86 The Fairway,
Aldwick Bay Estate,
Bognor Regis,
West Sussex.
PO21 4EX

Re: Planning Application No. AW/86/15/HH

Proposed

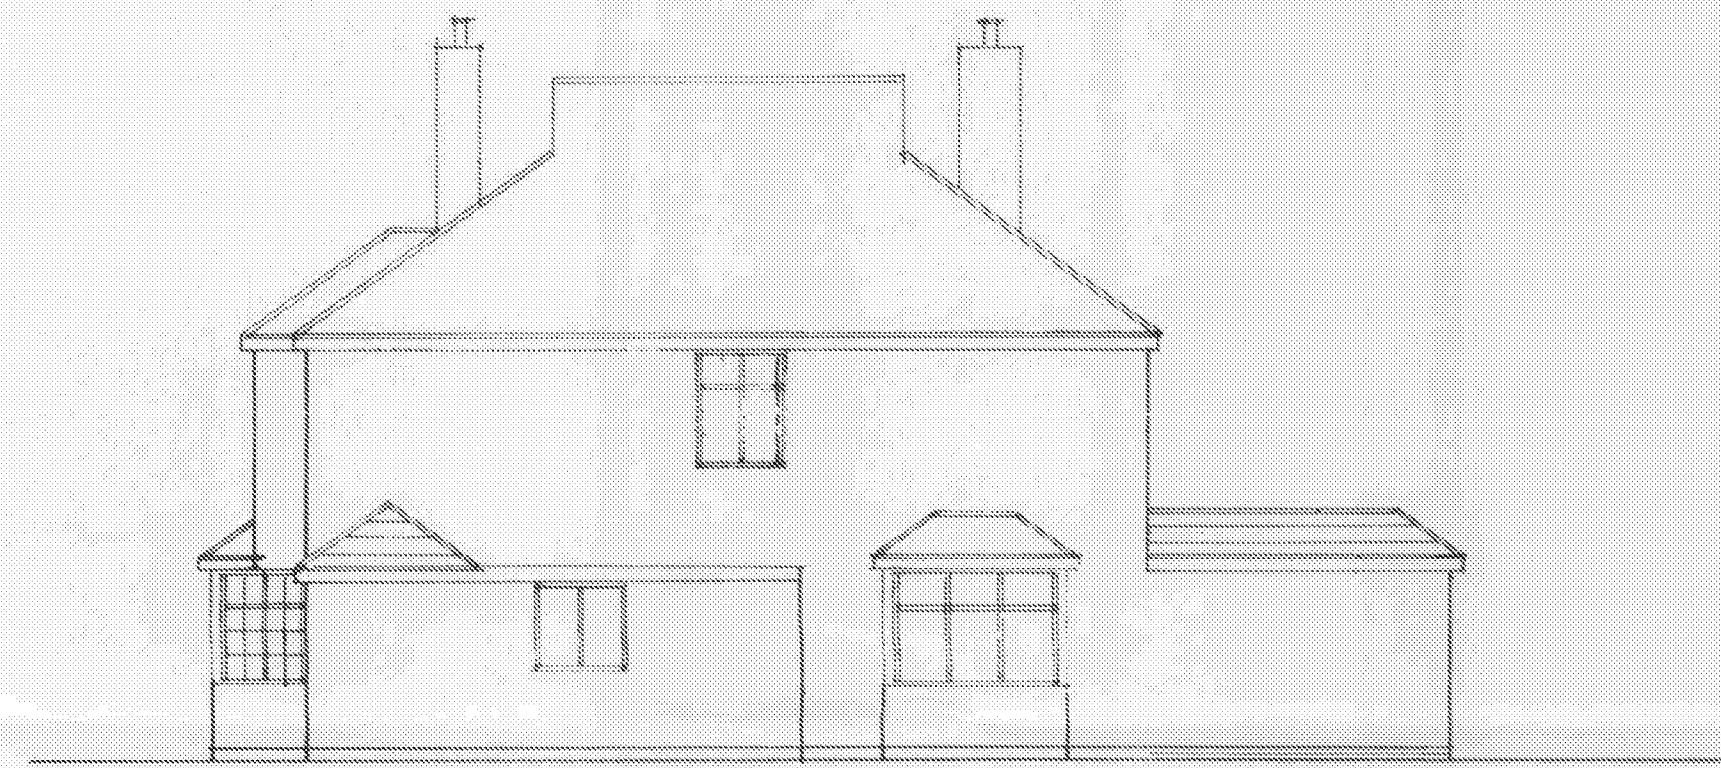
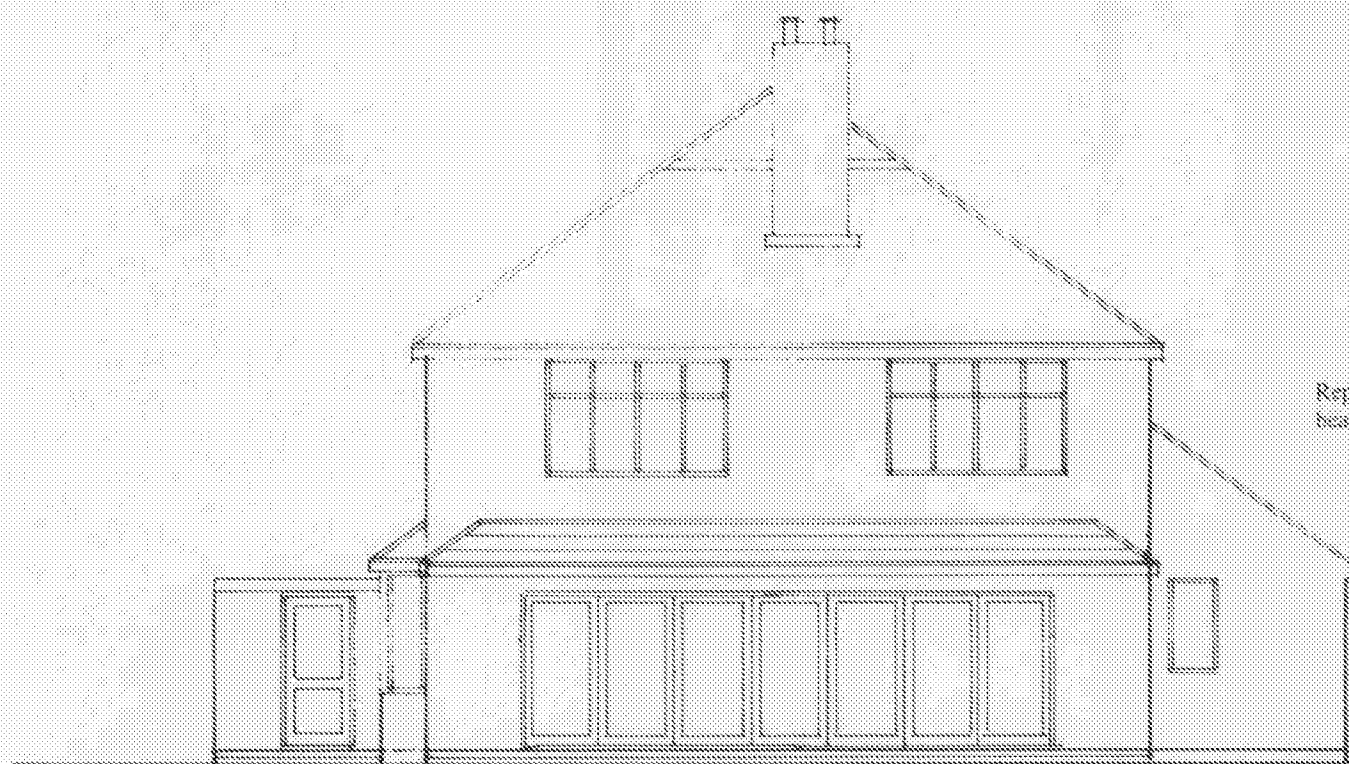
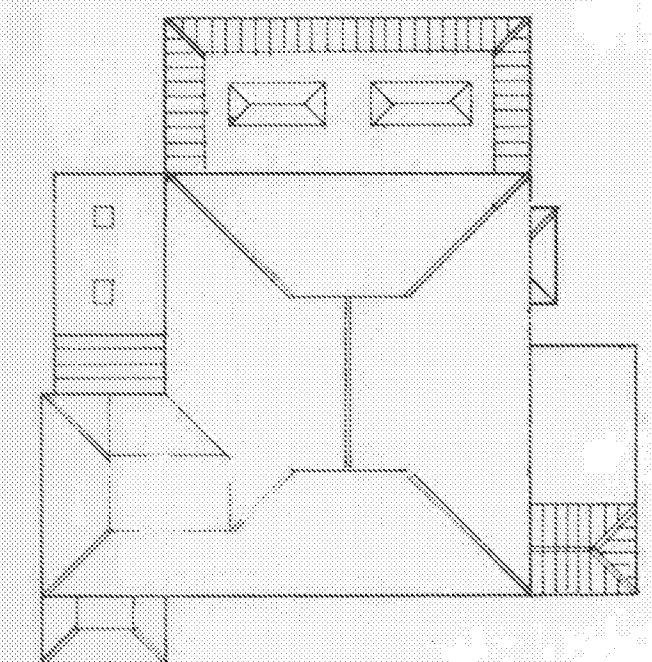
Part of the application seeks to extend the Western facing clay tiled sloping roof over an existing flat roof. No architectural details are provided. At this point, 87 The Fairway is only one metre from the boundary to our home.

The existing and proposed plans do not illustrate the existing "obscured glass" windows in the immediate vicinity of the West facing sloping tiled roof and how they will be affected by the proposed development.

The proposed development includes a large opening, non-obscured window to the new proposed kitchen side elevation which will overlook our property. It is also proposed to install two standard, non- obscured and fully opening large velux windows to the existing clay tiled sloping roof above the proposed utility/washing area which faces our property. This is only one metre from the boundary which will also allow the occupier to overlook our property. We will also be able to look into their house.

The proposed side window, two large velux windows and two large roof lights will flood our property and garden with light. The proposed full width fully opening glass bi-fold doors to the northern elevation will also directly affect other properties to the North. The proposal does not seek to minimise glare and spillage and will have a negative impact upon the wider locality. Policy Gen 33 is relevant as it highlights the damaging effect of inappropriate light upon the environment.

The applicant is seeking to install two large standard opening velux widows in their existing roof which directly overlooks our house. This will have a detrimental effect upon the overall setting of our property and certainly does not "preserve" or "enhance" the special character of the area.

The original timber windows at 87 The Fairway account for approximately 70% of the total frontage (excluding garage doors), and have particularly attractive timber mullions and profile generally. Changing the window design will have a detrimental effect upon the look of the house and its setting in the Conservation Area. The applicant has already acknowledged that they are seeking to create a "modern outlook".

The proposed development includes for new metal windows despite new double glazed painted white wood versions of similar profile and design being capable of manufacture. The proposal will not "retain the character and nature of the building and setting in the Conservation Area" and we do not believe is in accordance with ADC guidelines.

It is also proposed to remove the existing black "timber" cladding and replace with natural oak. Again, we believe this will dramatically alter the look of the house to its detriment. Replacement materials can easily be purchased if ADC concurs with the view of the Sir John Sloans' Museum and the Thirties Society that this is a "house of significance".

Plan
1 : 50

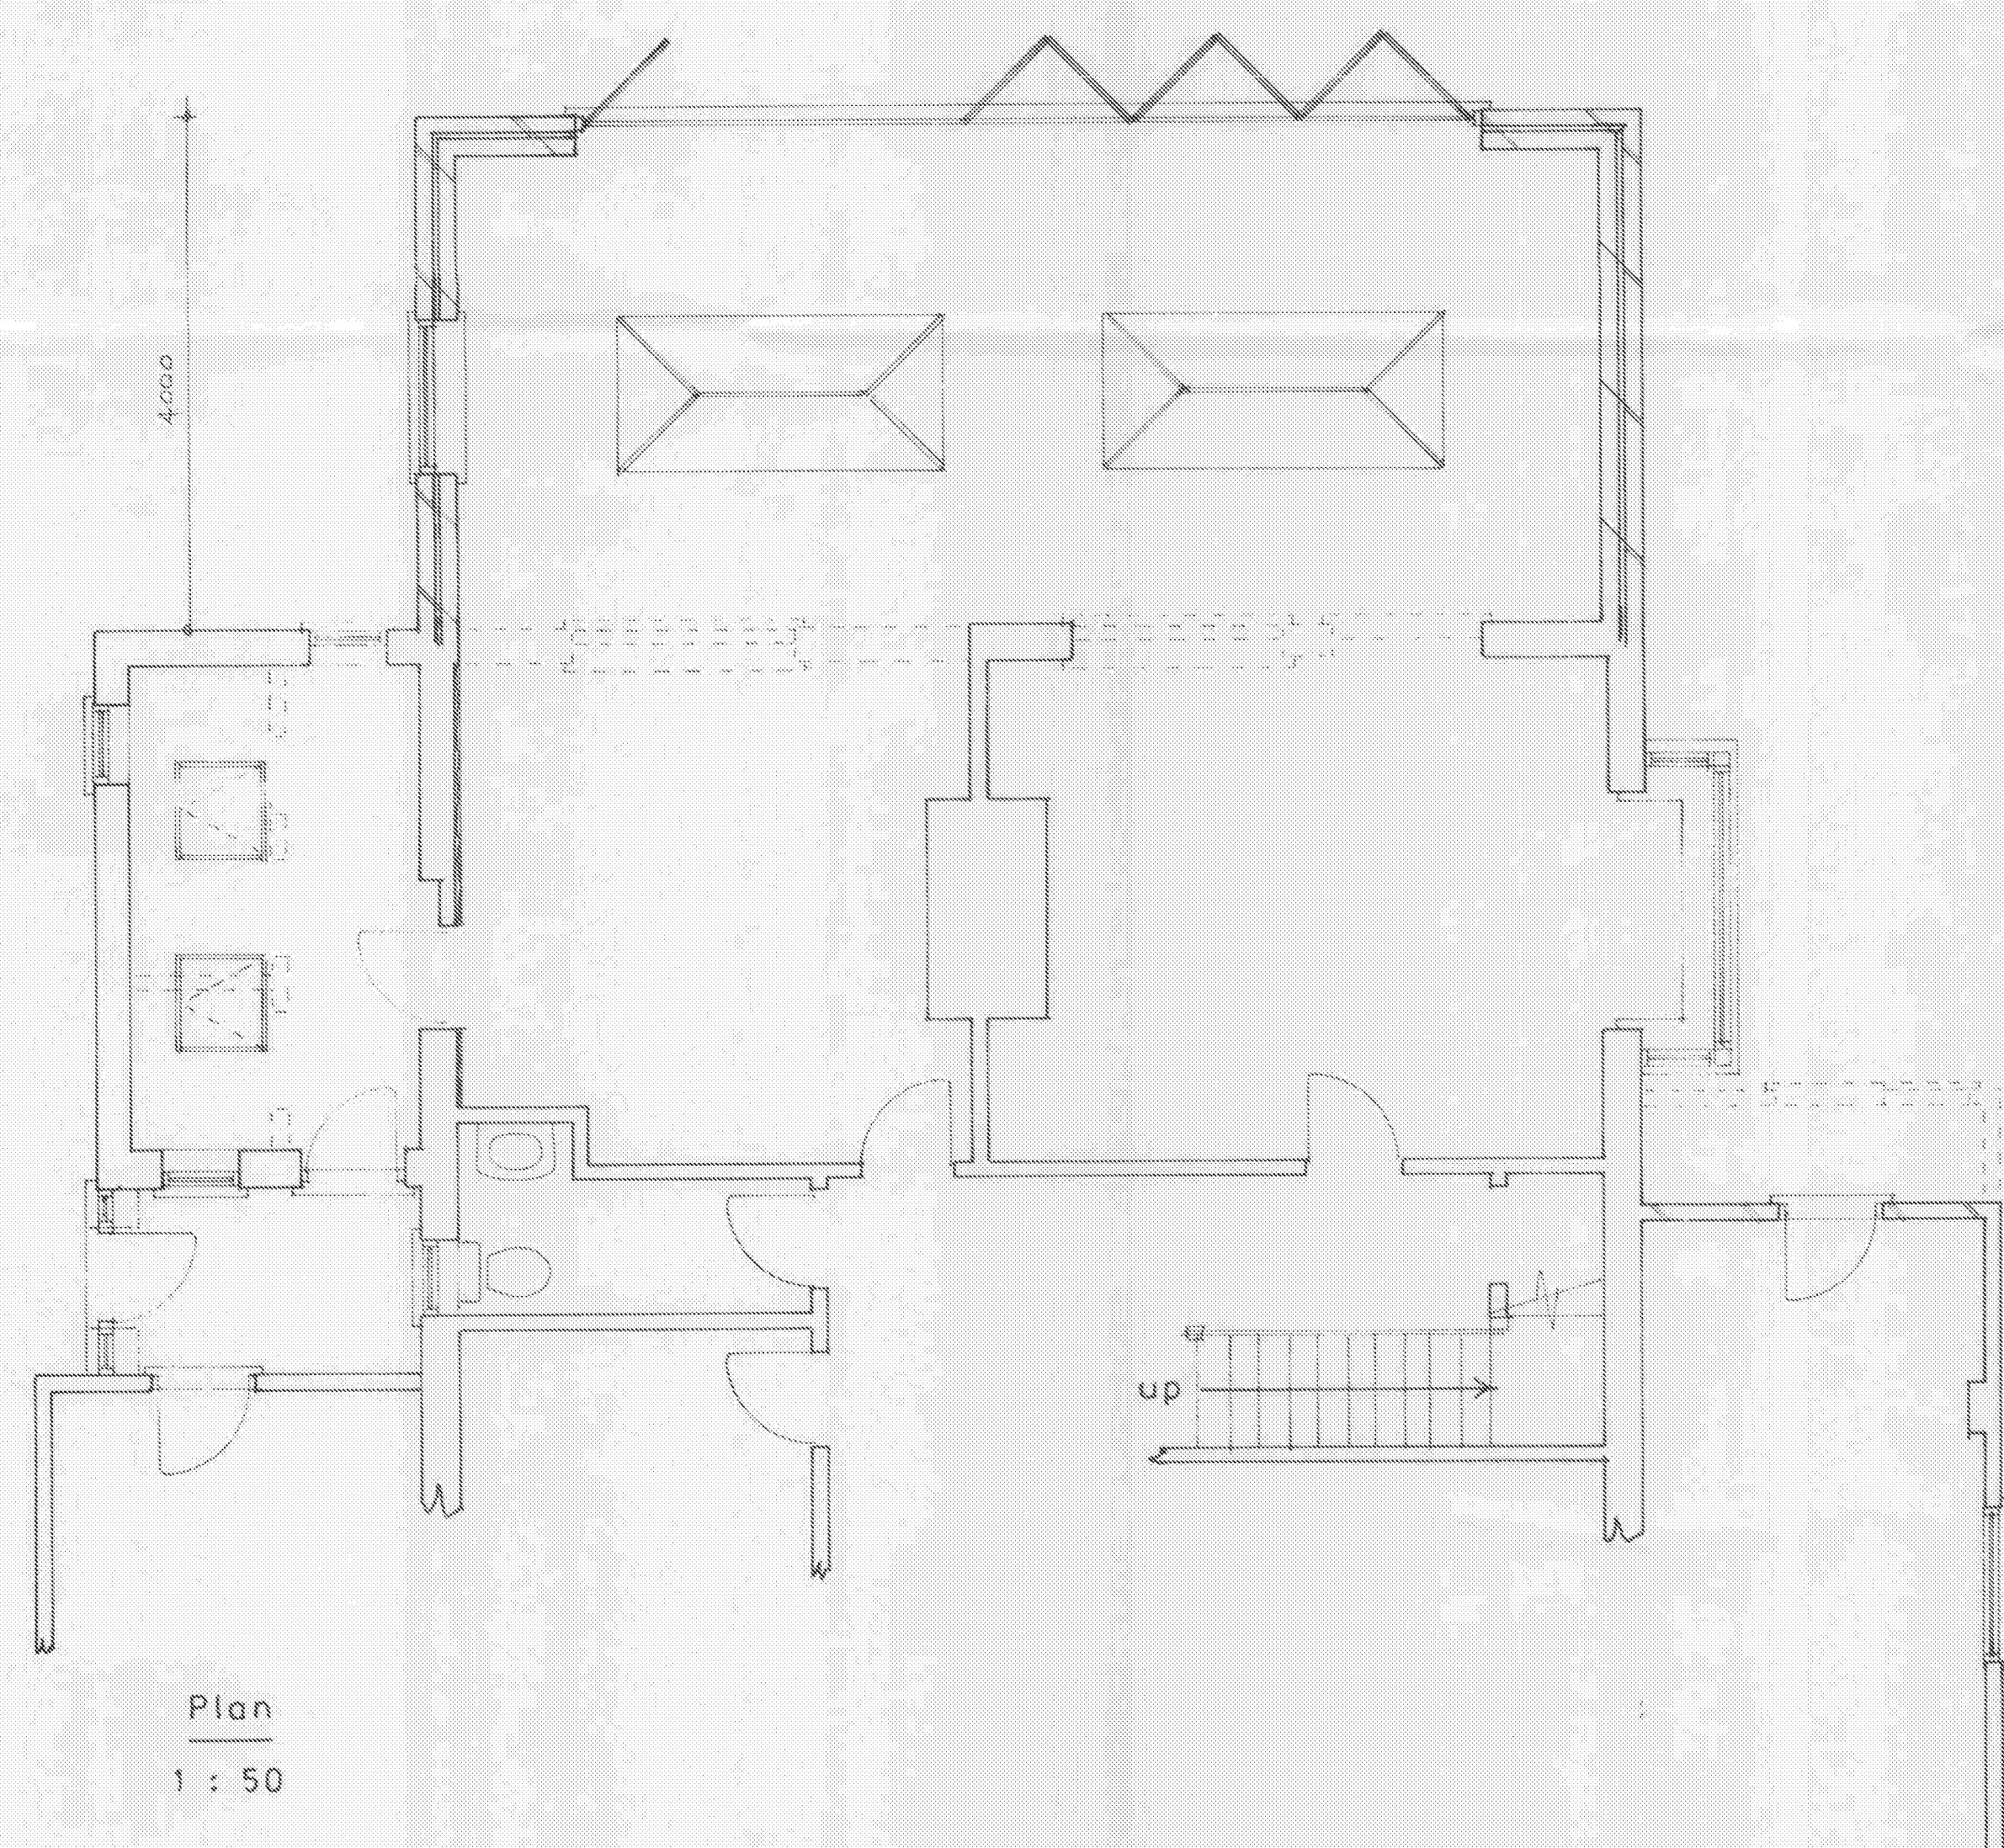
At 33 square meters (355sqft) this very large proposed development represents an approximate 50% increase in the current ground floor usable area and is out of scale to the main building and surroundings generally. It would extend at least 50% down the length of our garden, essentially "enclosing" our home. The overbearing effect will also be considerable due to the height of the proposed building at circa 3.35 metres, (11 ft). No maximum height is stipulated.

We are concerned that proposed cooker extract venting , smells and fumes from the use of a washing machine, tumble dryer, dishwasher and other apparatus will damage the quality of the immediate environment and cause potential health and safety issues for our family. The location for such items will only be one metre from the boundary and directly adjacent to our patio where meals are taken. The proposal is not in accordance with Policy Gen 34.

No measures have been included to reduce noise pollution from the kitchen and utility area. By incorporating a side facing opening window to their kitchen and two large opening velux windows to the new utility area, we are likely to suffer from significant noise.

block plan
1 : 500

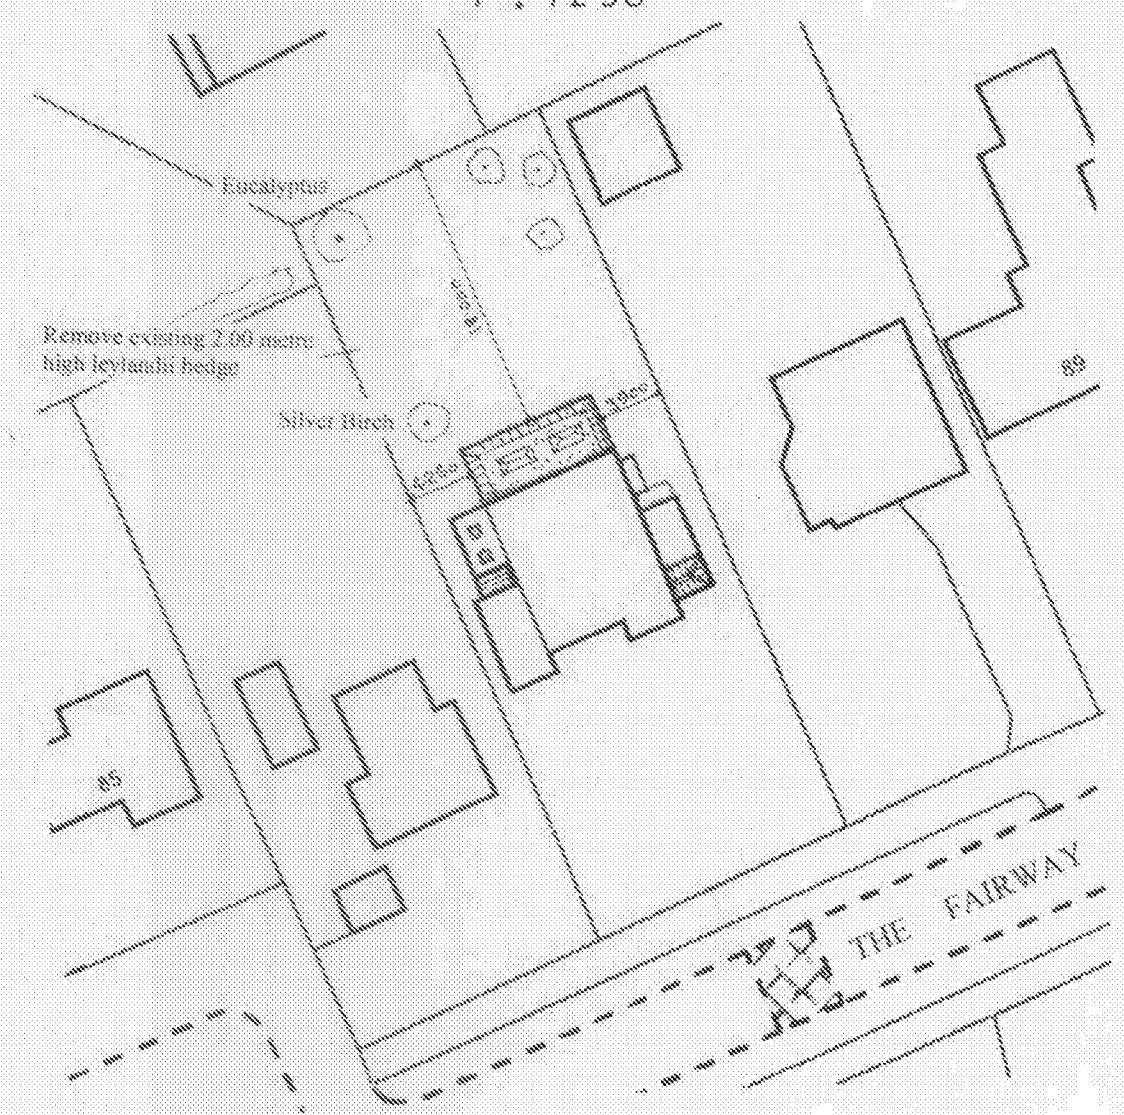
The block plan provided by the applicant is significantly out of date. It does not correctly illustrate the extent of our property or the proximity of the applicants proposed development to surrounding properties.
